SSD 7462

**Bingo Resource Recovery Facility, 13 Pembury Road, Minto (SSD 7462)
Request for Response to Submissions**

ATTACHMENT 1 – DEPARTMENT OF PLANNING AND ENVIRONMENT ISSUES

TITLE
25.0m B-DOUBLE - SWEEP PATH

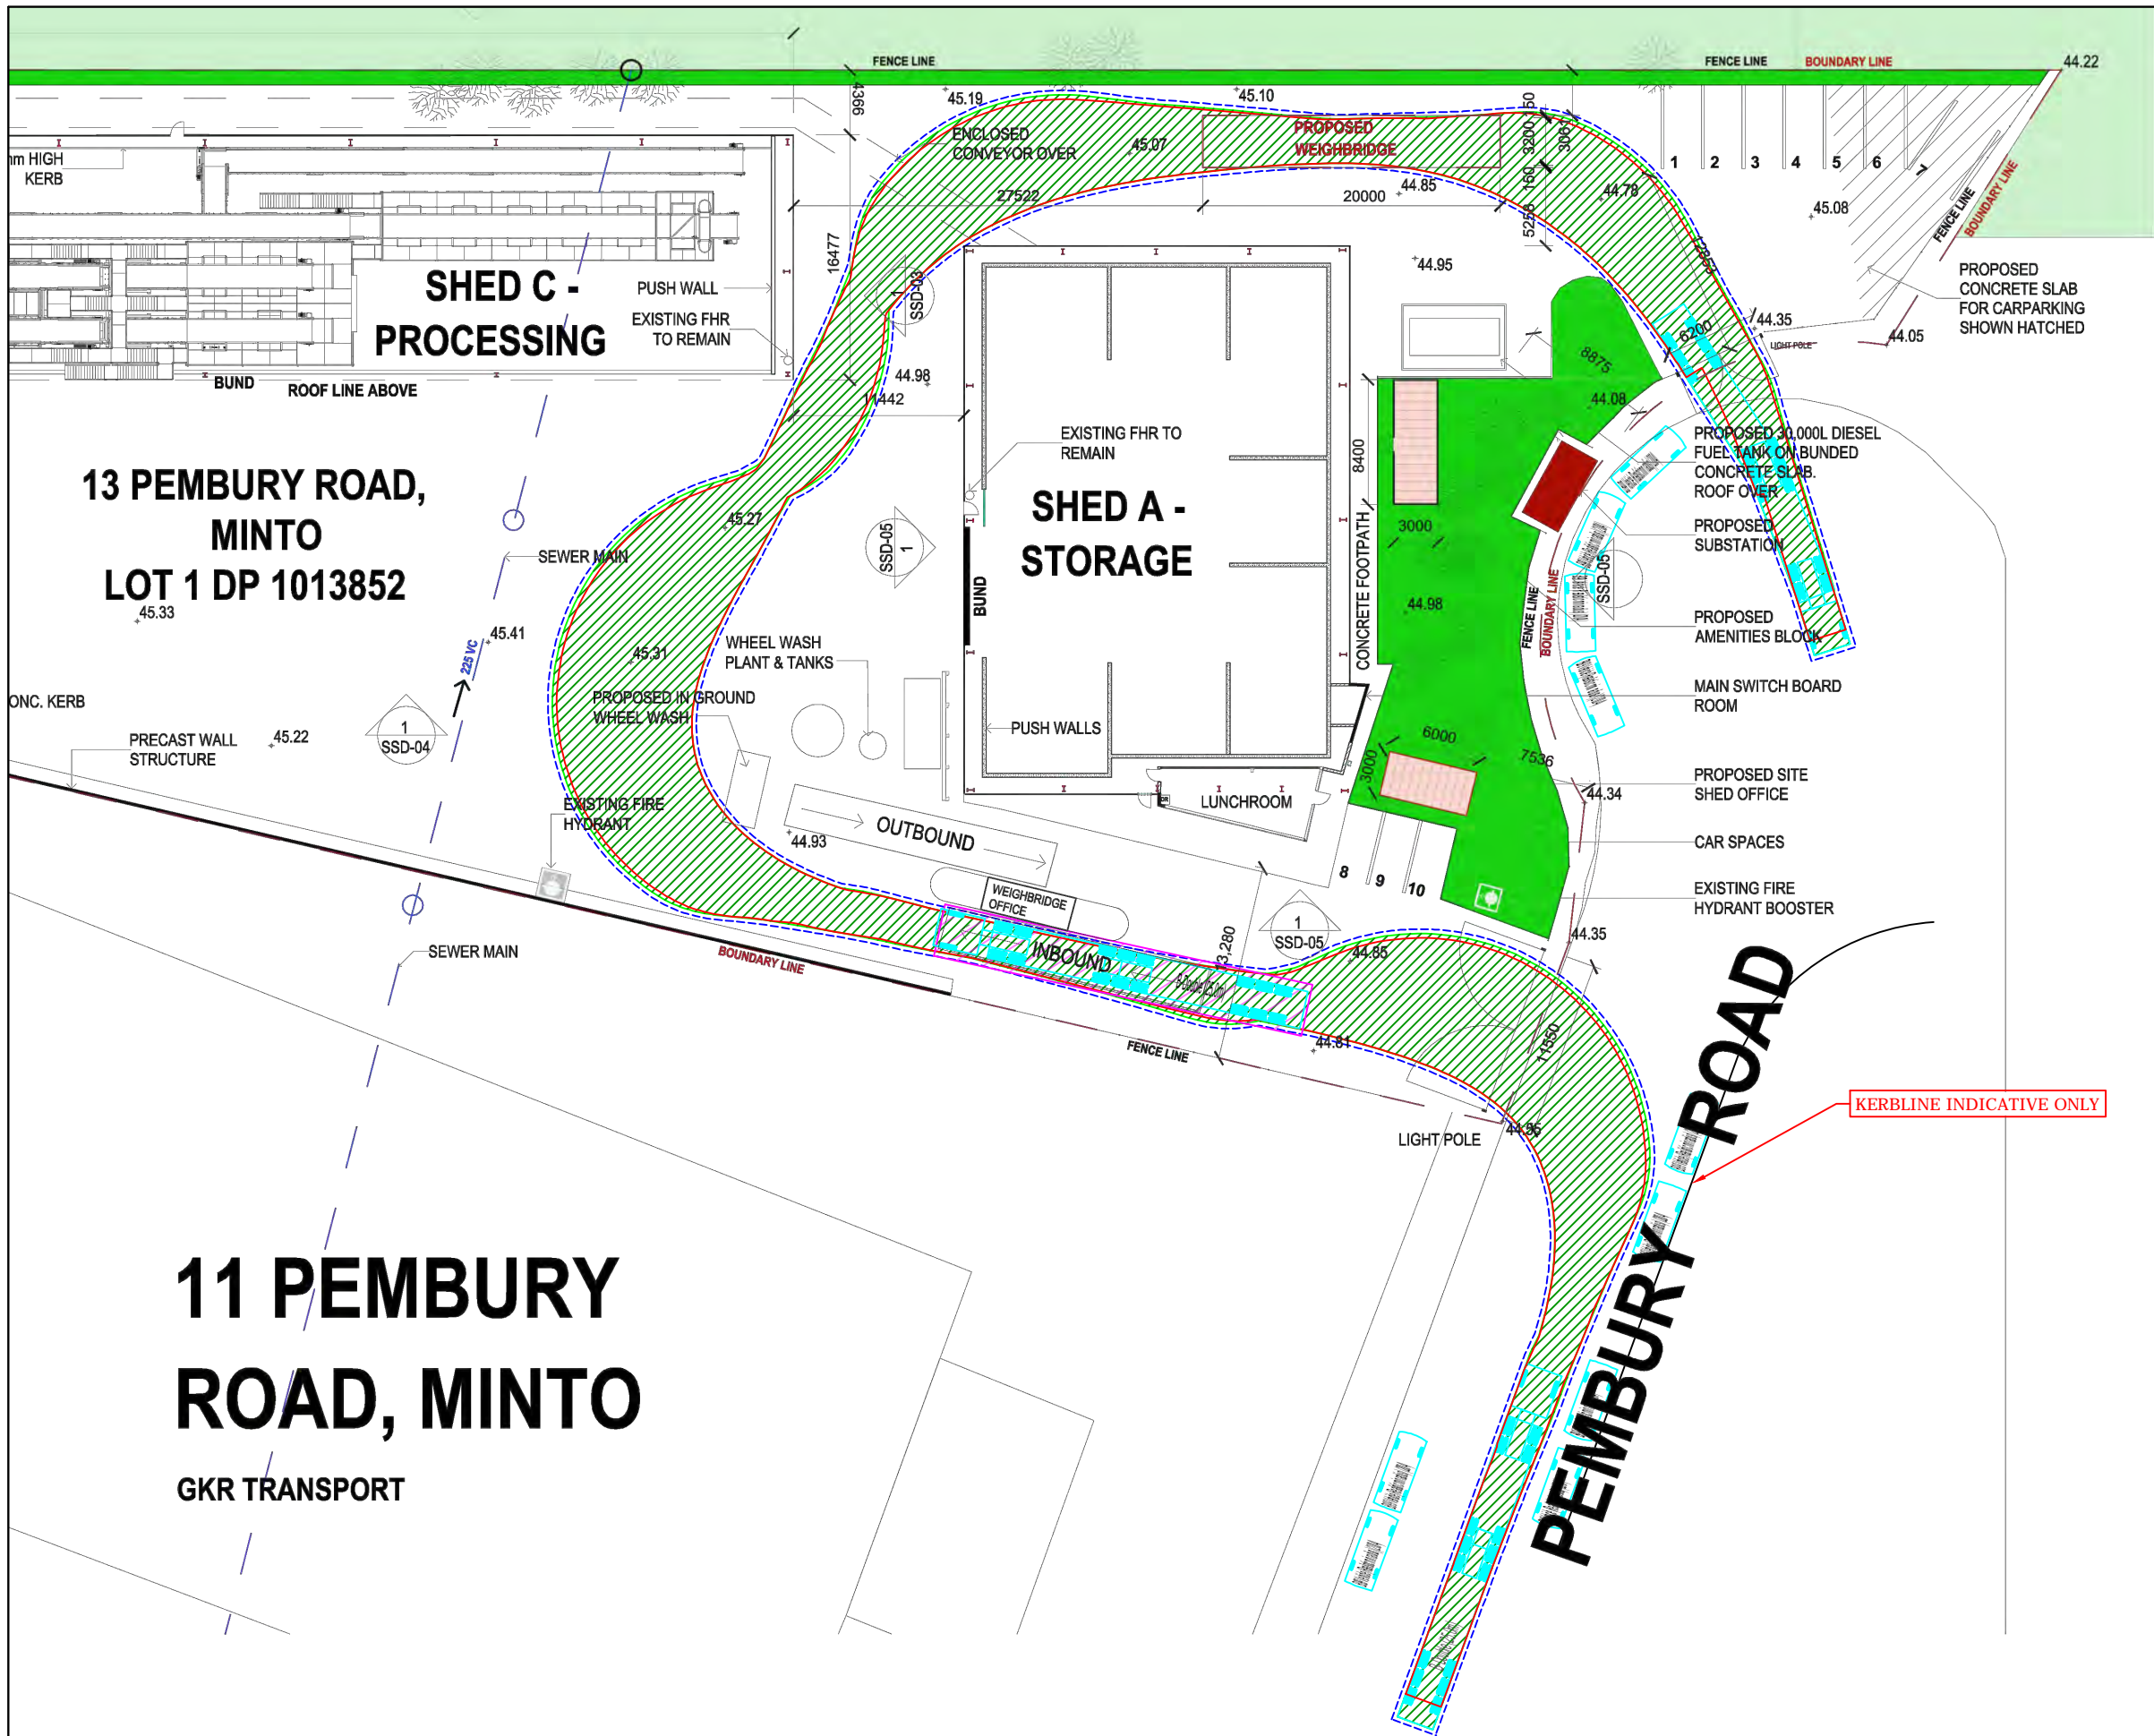
27. Section 6.7.4.3 of the EIS states that the largest vehicle required to access the site will be a 25 metre B-double truck. The EIS advises that large vehicle movements can be undertaken without crossing the road centre line. However, the swept path analysis for 25 m B-double trucks show vehicles will use most of the road width of Pembury Road to access the site. Please clarify this discrepancy.
